**WELWYN HATFIELD BOROUGH COUNCIL
EXECUTIVE DIRECTOR - PLANNING, PUBLIC PROTECTION AND GOVERNANCE**

DELEGATED APPLICATION

Application No: 6/2021/1017/EMH
Location: 37 Sherrardspark Road Welwyn Garden City AL8 7JY
Proposal: Erection of a first floor side extension
Officer: Mr James Homer

Recommendation: Granted

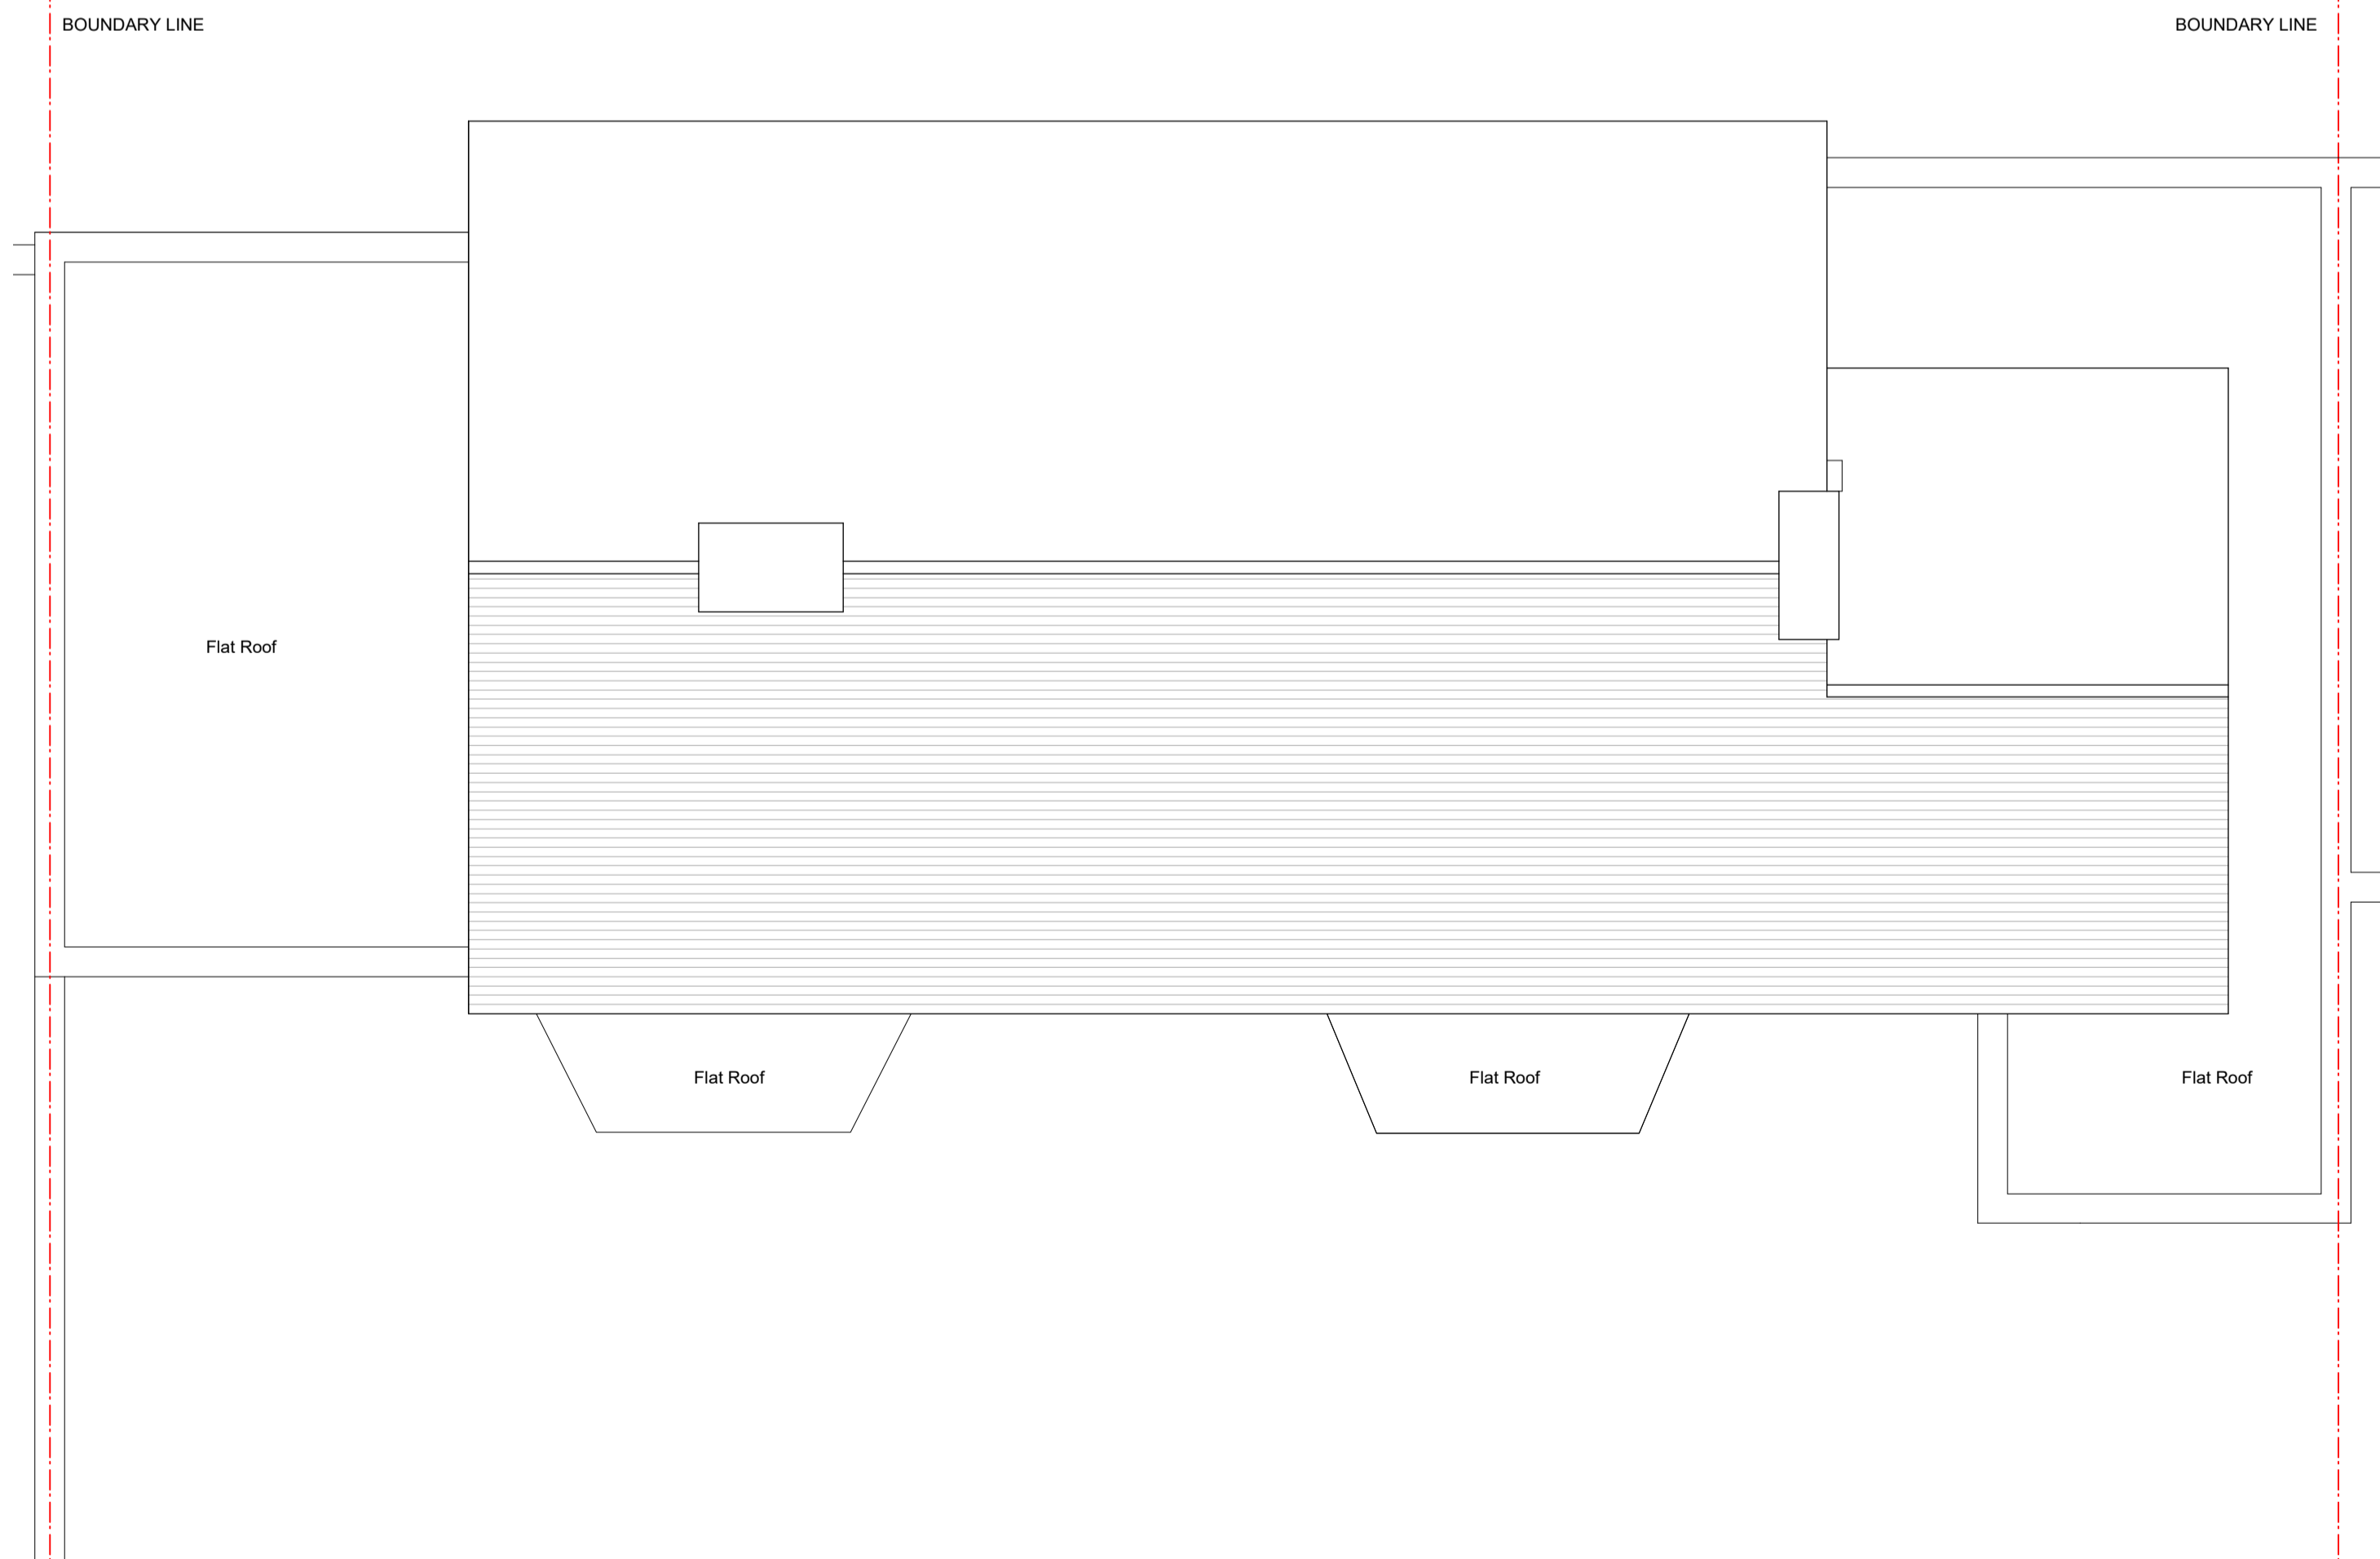
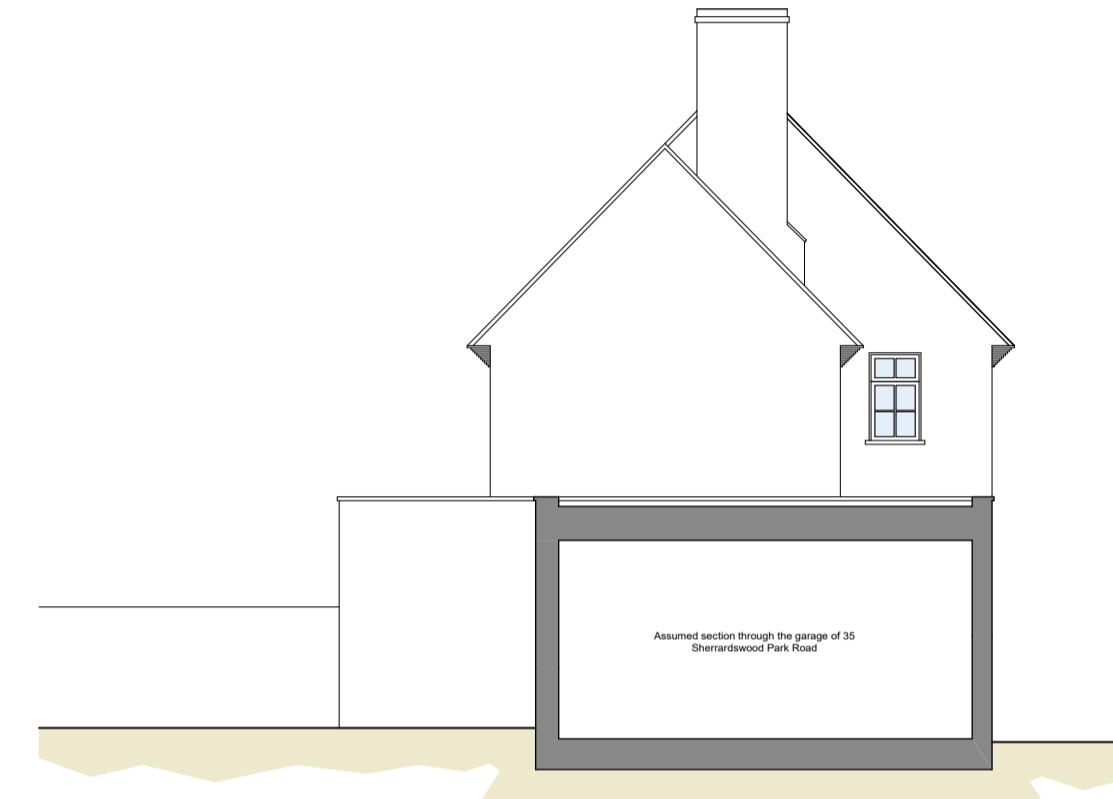
The proposed first floor side extension would be on the eastern flank and would have a width of approx. 3.2m. The extension would be set back from the front elevation of the main house by approx. 2m and set down from the main ridge by approx. 1m. Although level with the rear elevation of the main dwelling, the proposed extension would appear proportionate and subordinate to the existing house. Importantly, the existing chimney stack on the eastern flank of the original home, which is a key feature, would remain. The proposed extension would feature a window within the front and rear elevations. The plans indicate that the window design and placement would match the existing fenestration.

The proposed extension would leave a separation gap of approximately 1m between the flank wall and the common boundary with 35 Sherrardspark Road, however the overhang from the eaves and roof would reduce the gap to approximately 900mm. The spacious gaps between houses is a key feature of the Garden City design and it is important that sufficient spacing is retained to preserve the character and appearance of the Estate Management Scheme area. Sherrardspark Road is characterised by properties with varying design, however, generous spacing at first floor is a common feature. It is therefore, important that sufficient spacing is retained between the application site and neighbouring properties. Whilst the proposed extension would reduce the space between the property and the boundary of the site to approx. 1m at first floor, the two storey flank wall of the neighbouring property at no.35 is situated a significant distance away from the boundary and sufficient spacing is retained.

The proposed extension would result in the flank wall of the property moving closer to the shared boundary with no.35. However, as stated above, sufficient spacing remains and it is considered that the extension will not result in a harmful loss of privacy, outlook or light to this property or any other neighbouring home.
